Sketch Plan Land Uses

WATERVIEW

2020_SKETCH_PLAN_AMENDMENT

SHEET NO. **2** of 2 SHEETS
 PLAN SHEET
 DSE_NO_01-02-19-05

COVER SHEET

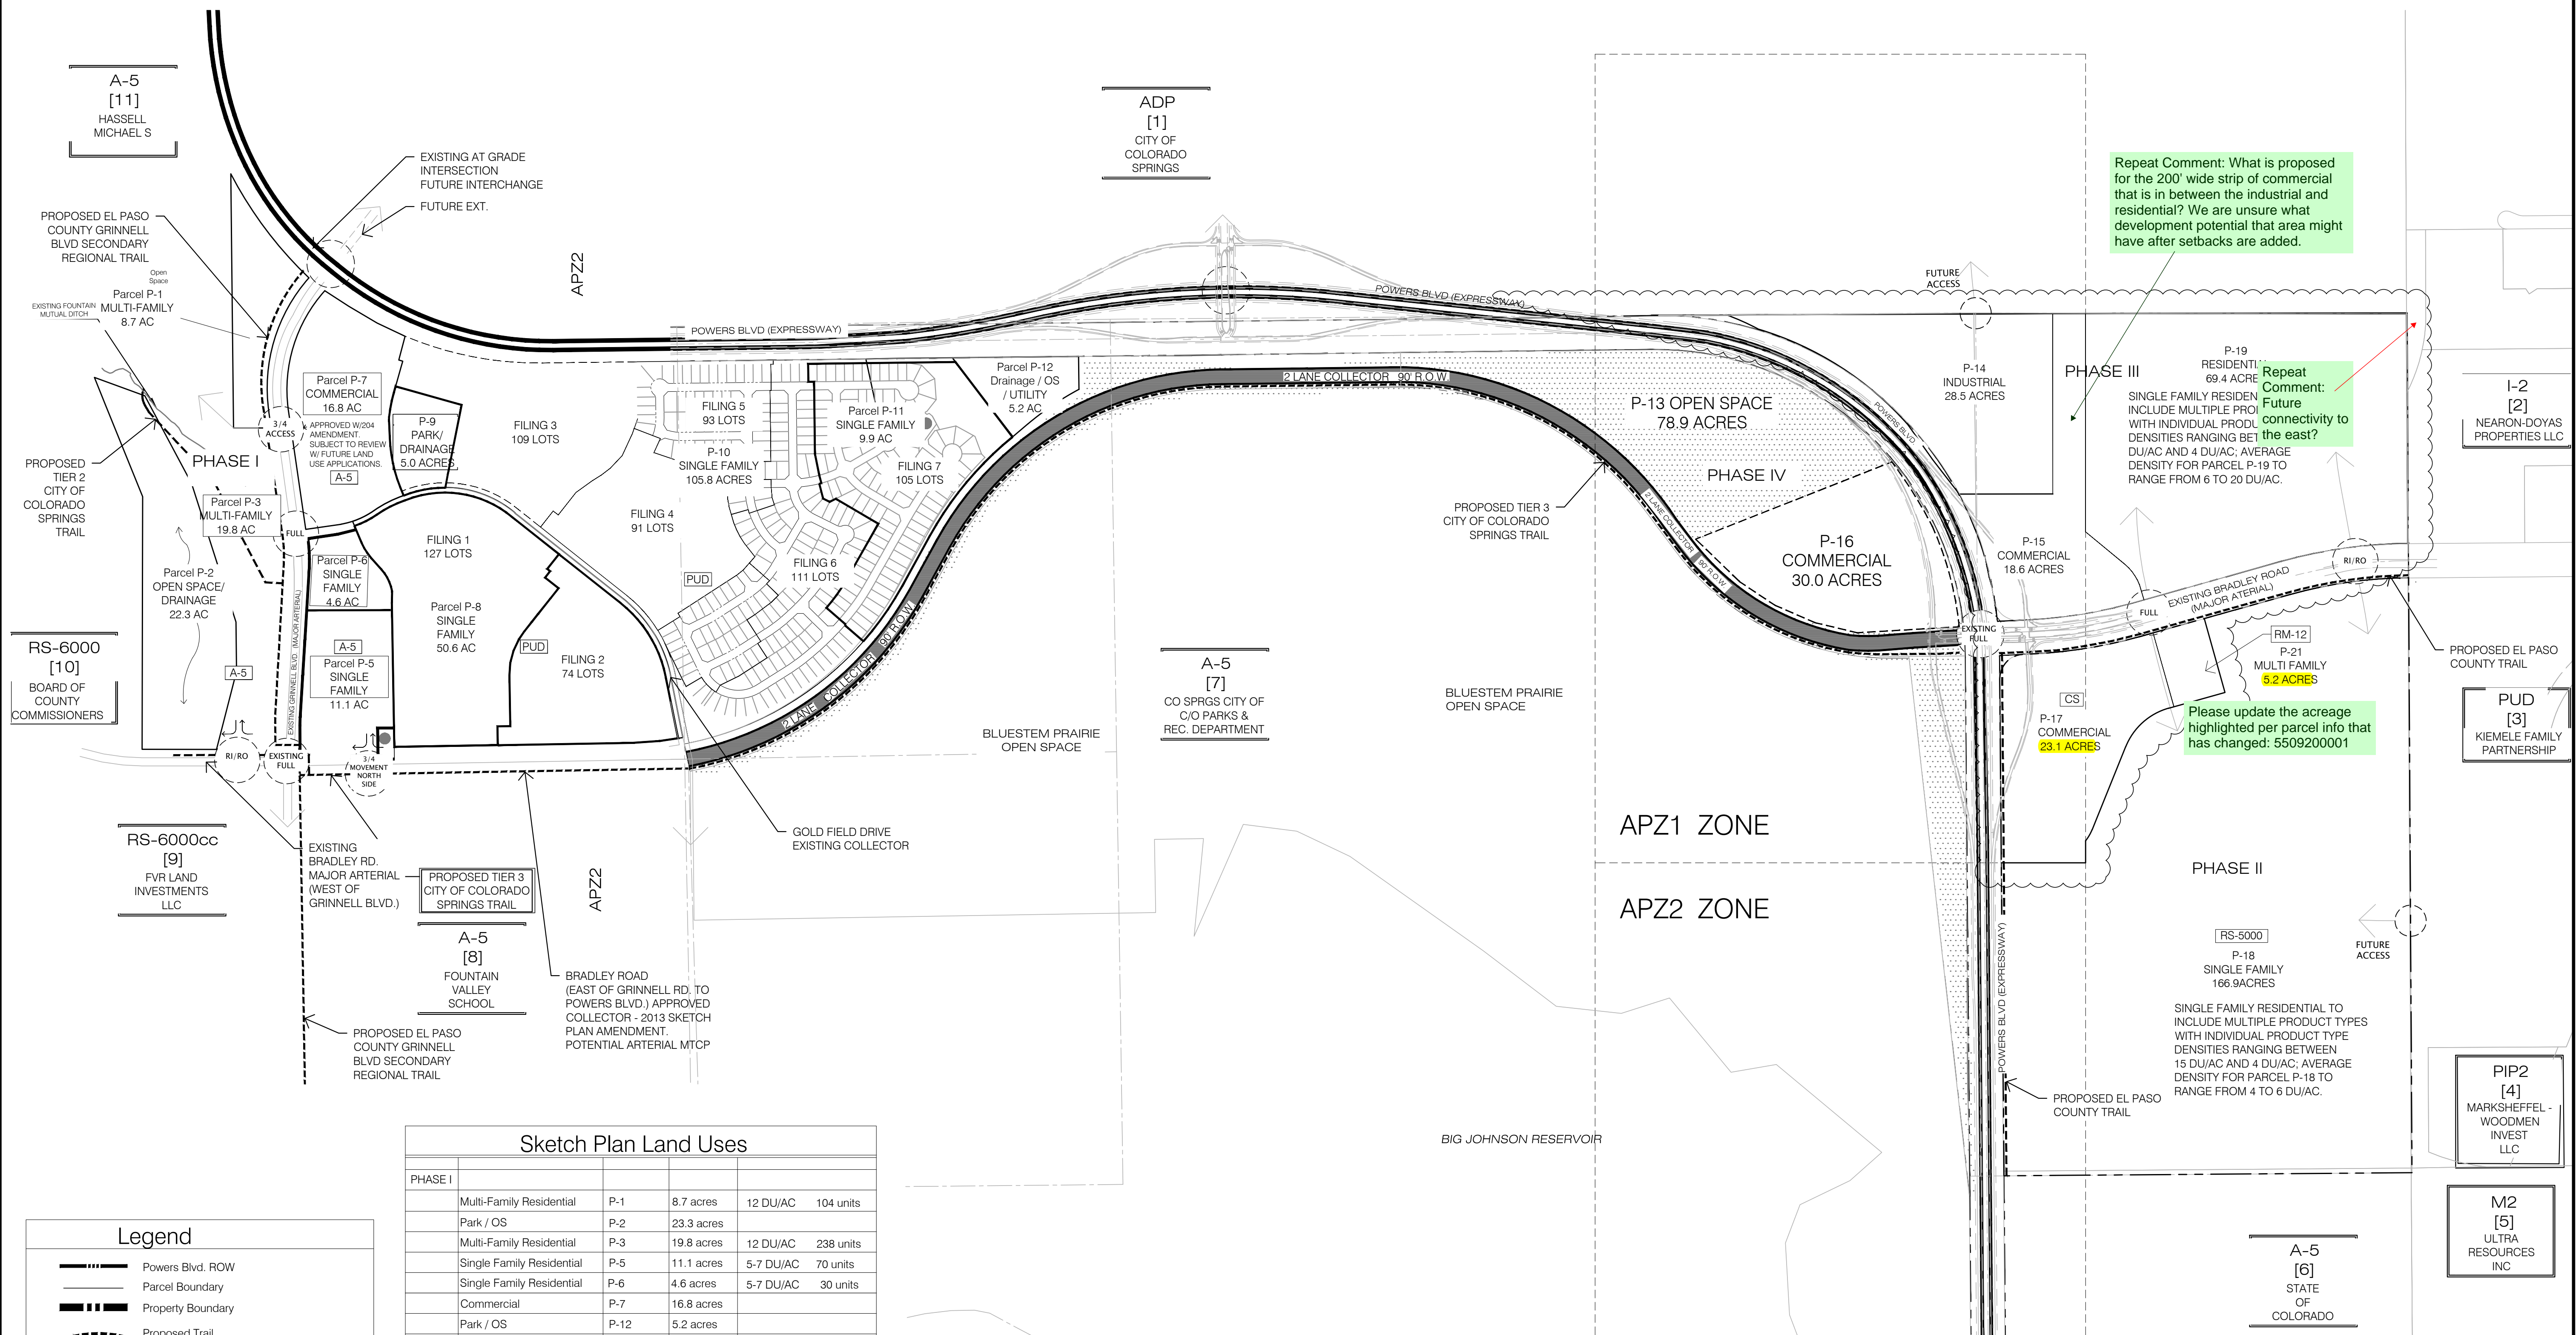
Does not match information on sheet one. Please revise
